I am writing to you to express some concerns over the recent application [6/2023/0005/HOUSE](#)

The plans and elevations on the portal illustrating the existing building are extremely inaccurate and do not reflect the existing building in any way:

MRS GLORIA ROWLAND
Home Extension
391 St Albans Road West, Hatfield, AL10 9RU
Existing Gound, First
Second & Roof Plan

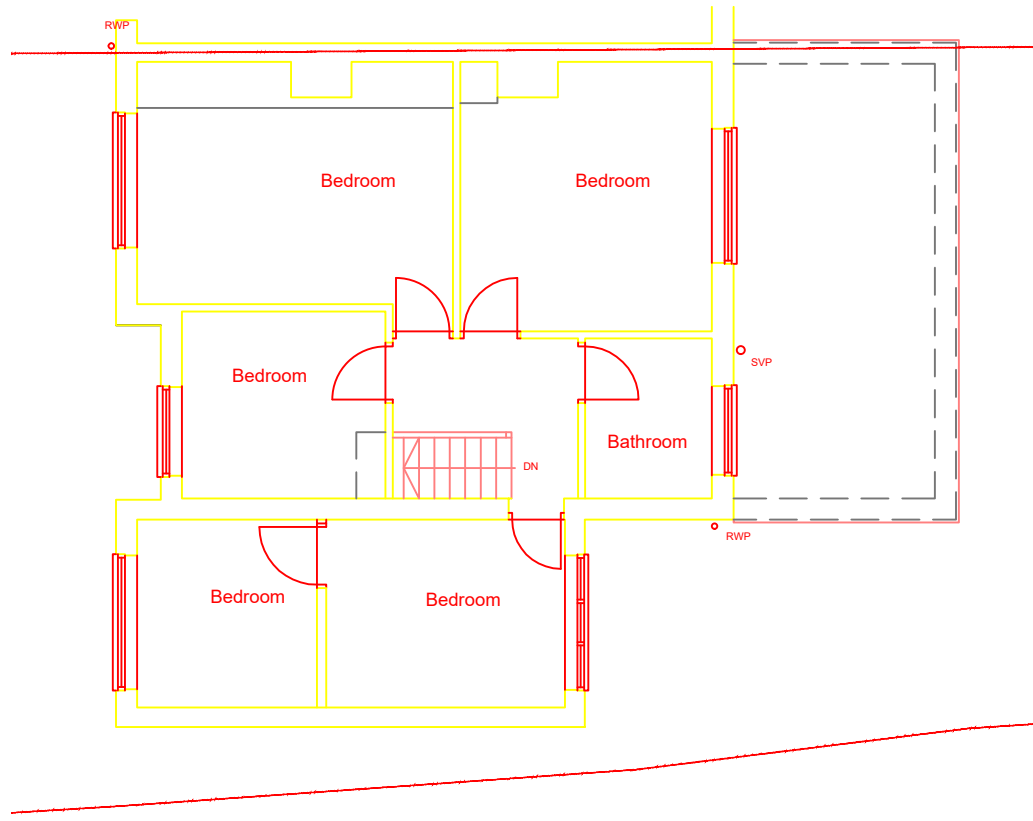
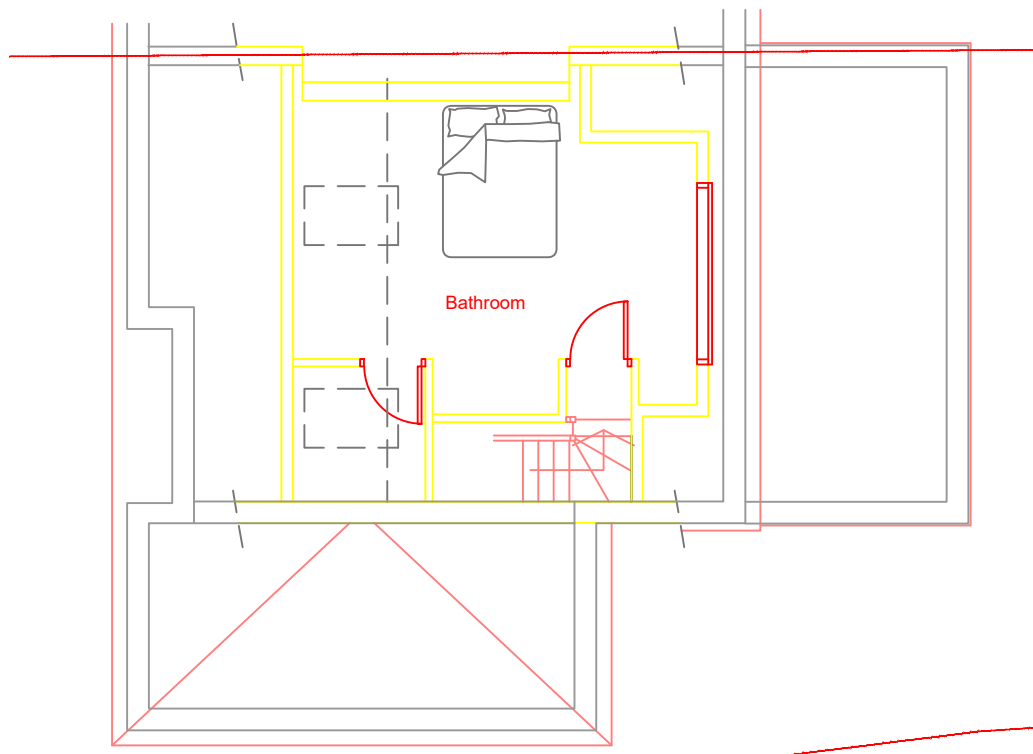
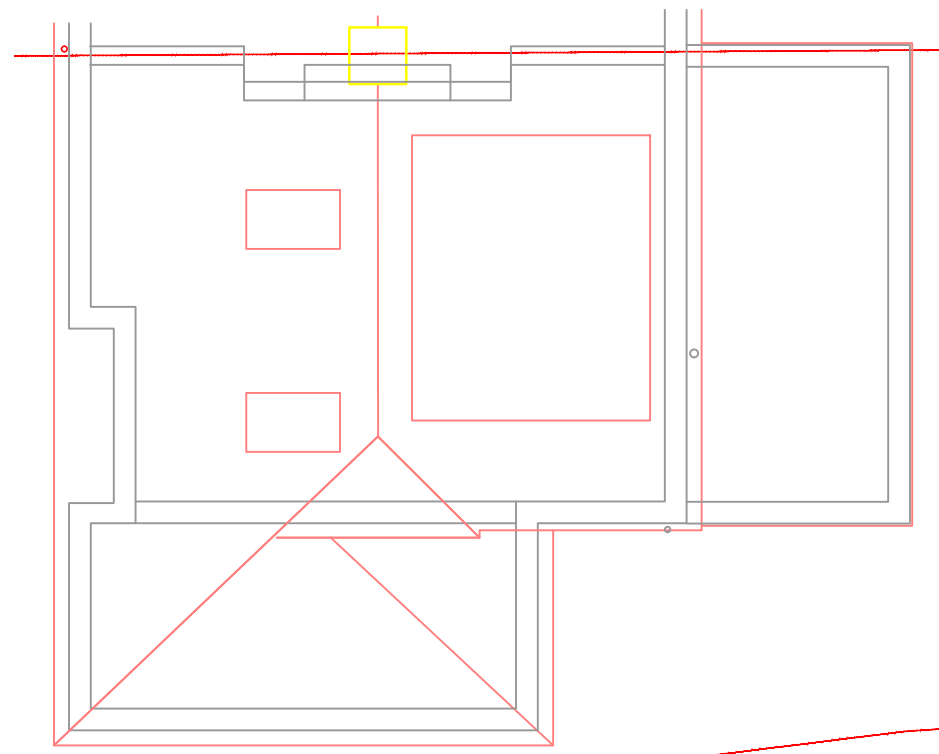
- There are no existing roof windows on the front roof elevation.
- There is no existing dormer on the rear roof elevation.
- The major ground and first floor rear extension together with its alterations to the roof structure (erected by a previous owner) have been completely omitted from the plans.
- A substantial (unlawful) outbuilding already existing immediately adjacent to and partially connected to the main house, has been omitted from the plans

Existing Shed
Ground Floor & Roof Plan
Front Elevation & Section

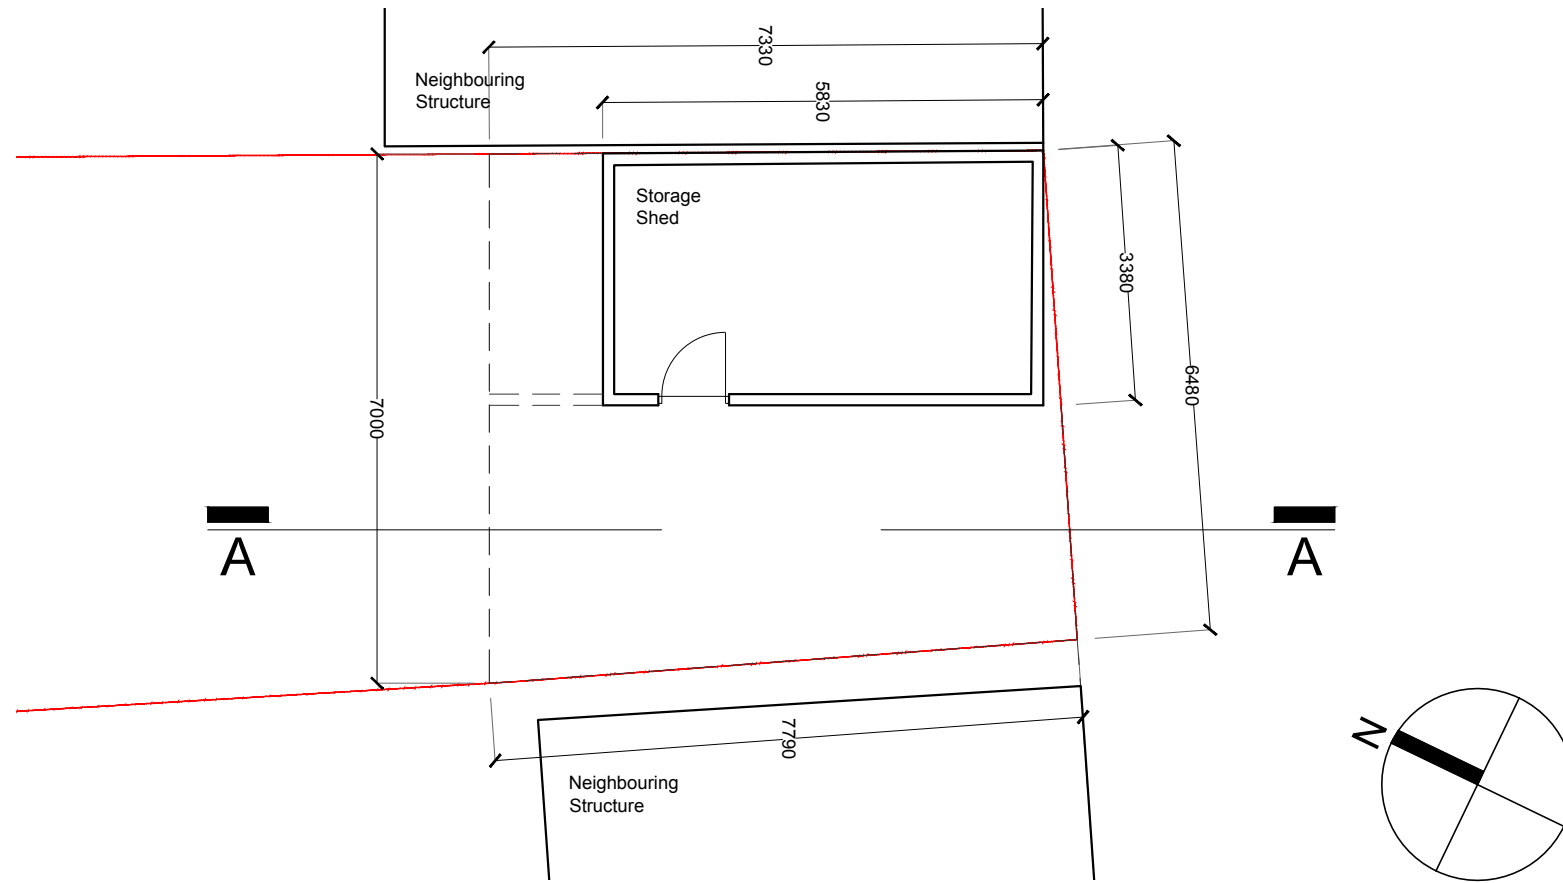
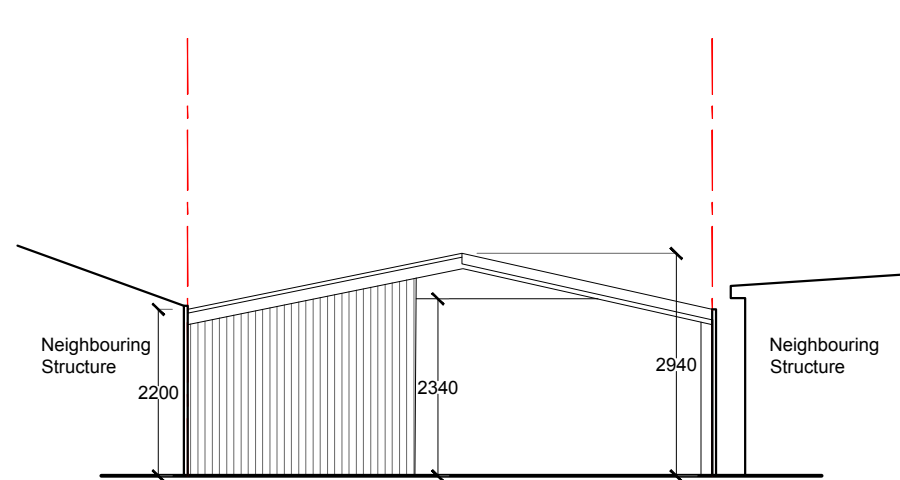
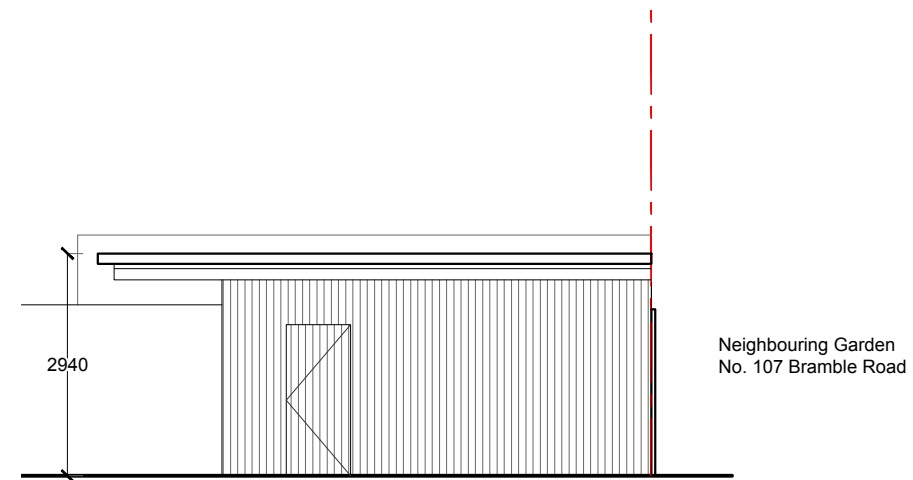
As previously outlined, there already exists a large outbuilding (>50sqm) at the immediate rear of the main residence. This building was granted a certificate of lawfulness (S6/2014/2413/LUP) based on submitted plans and conditions attached to the decision as a 'games room'; this building is unlawful as it is circa twice the size of the approved plans, built over a public sewer and is fitted and used as habitable accommodation in direct contravention of the planning conditions. This building has been deliberately omitted from plans, descriptions and notes provided with this application and previous applications.

Visual examination would suggest it does not meet building regulations and is overhanging the property boundary.
